Planning and Regulatory. G.Mansfield
Reference: PB2016/09668
Phone: 02 4974 2767

**NOTIFICATION OF MODIFICATION TO MAJOR PROJECT TO CREATE A
SUBDIVISION (MP06_0031 MOD2)**

I refer to your email of 4 October, 2016 advising that Hunter Medical Research Institute has submitted a modification request to include subdivision for the site and inviting Council to comment.

Fig 2: Extract Plan of Defendable Spaces (Inner Protection Zones) and Fuel Managed Areas (Outer Protection Zones) per ABPP Bushfire Protection Assessment for the Construction of the HMRI Building per ABPP Assessment Report No. B08900 dated 18/08/2009.

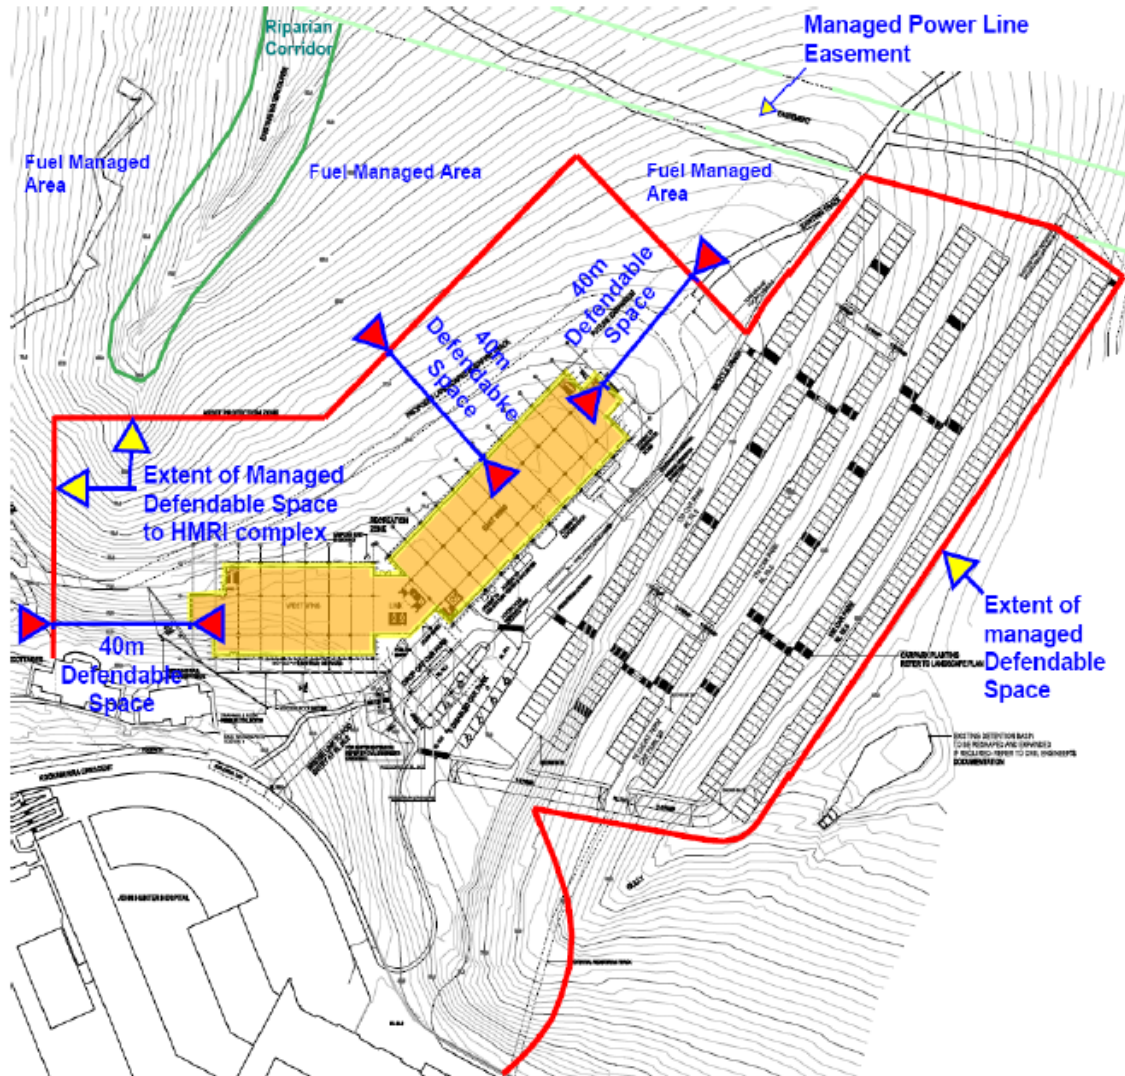
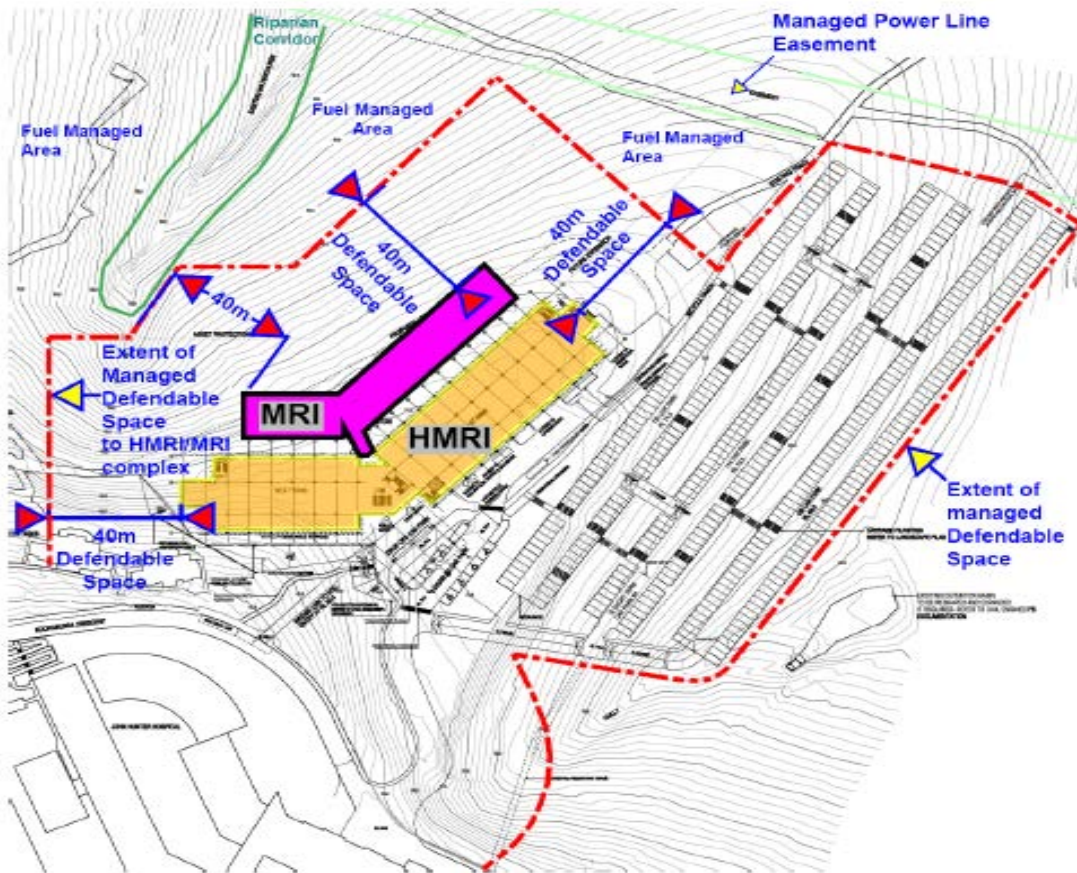
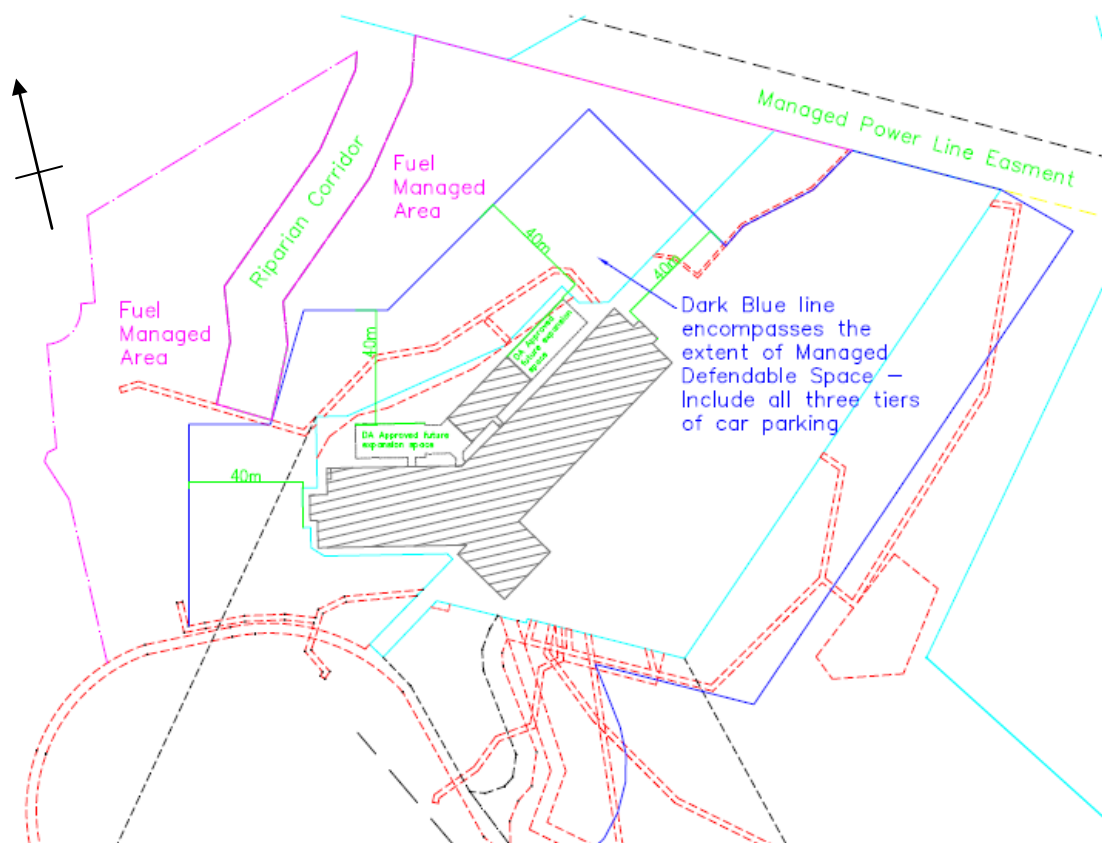
6. The extents of (KK) and (JJ) to the west of the HMRI building are different, respectively, to that shown as Defendable Space and Fuel Managed Area in the Bushfire Protection Assessment by ABPP Ref. BO8900-2 dated 18 August 2009).

Fig 1: Original Plan of Subdivision Document Ref CRH12-354C_DP_2A.pdf. This extract from the plan of subdivision whilst not appended to the NCC comments, has been included to aid in understanding of the ZHMRI response to the comment.

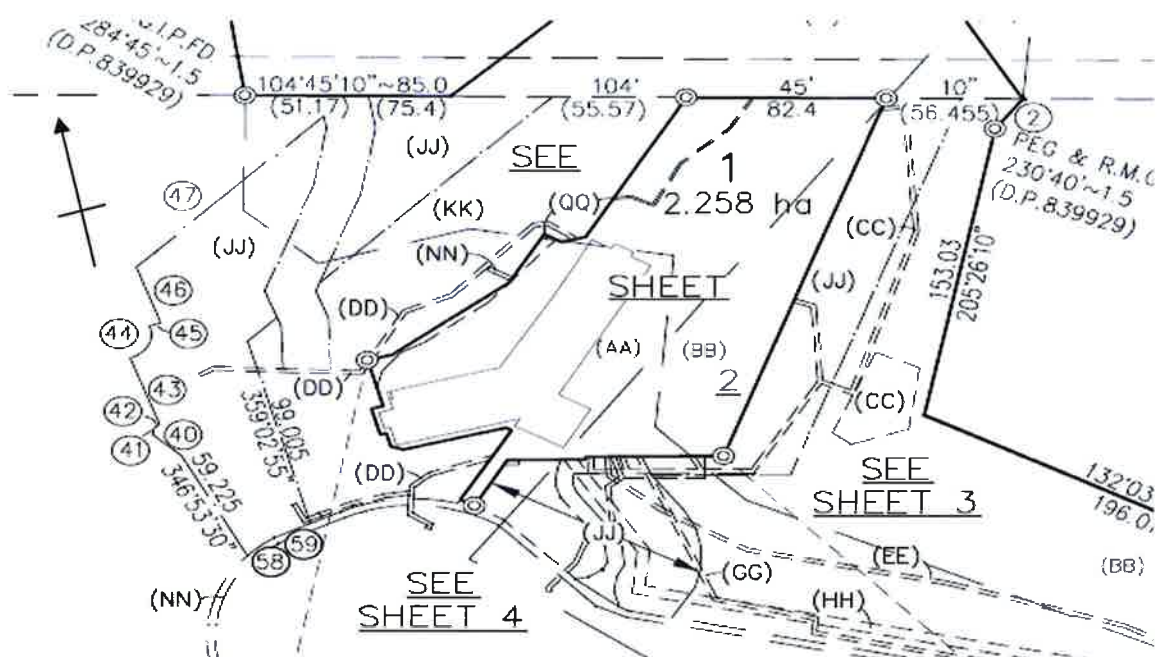
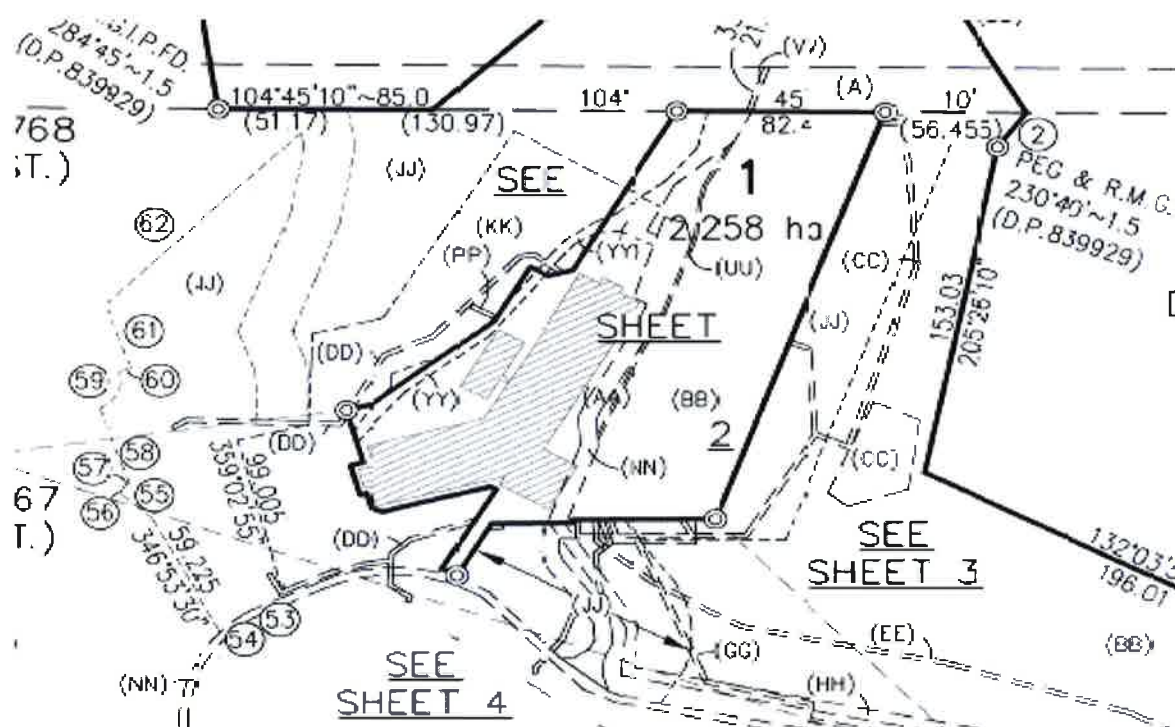
5. That part of the land shown burdened by easement (JJ) Outer Protection Zone to the east of proposed Lot 1 should be notated as (KK) Inner Protection Zone is to comply with Statement of Commitment 7.4 Bushfire - Recommendation 2 (See Appendix B of the Project Approval).

Fig 6. Conditions of Consent Drawing K1002 - key Drawing Access & Movement Pedestrian & Bicycle Movement

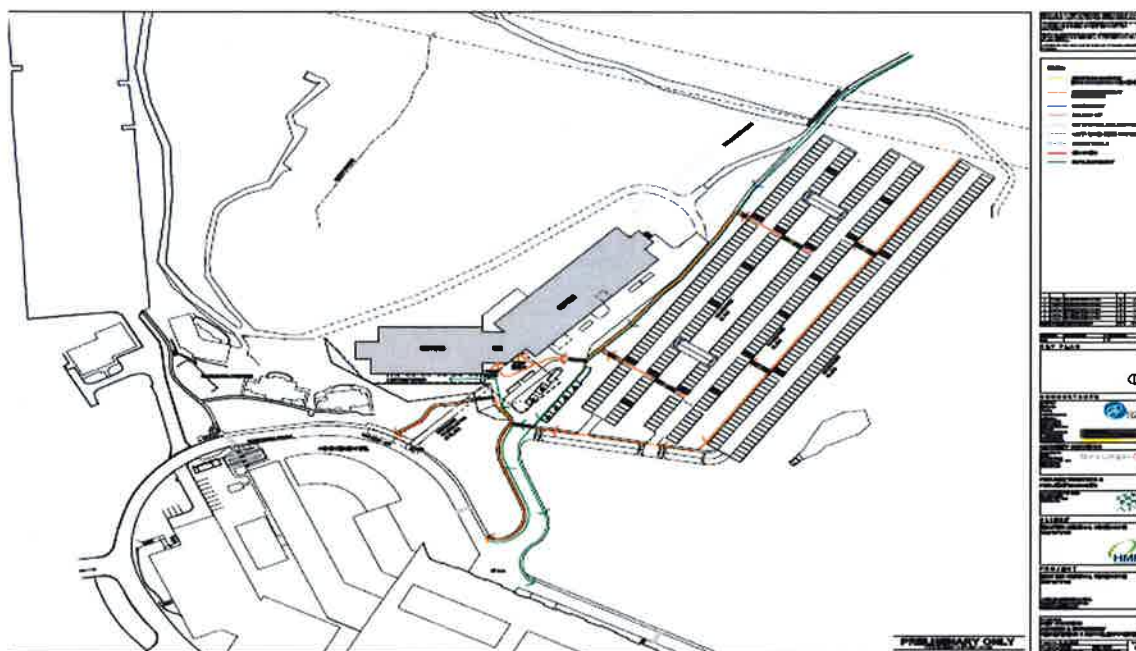
8. The shared pathway entering proposed Lot 1 from the bushland to the north appears to be at least 2.5m wide, however proposed Easement QQ is noted as a Right of Footway 1 wide and variable. It is also apparent from aerial photographs that the shared path provision extends further south than as depicted on the draft DP. The easement should be amended wholly contain this pathway. Consideration should also be given as to who is to have benefit of this easement as members of the public might use this pathway to access the wider HNEH campus.
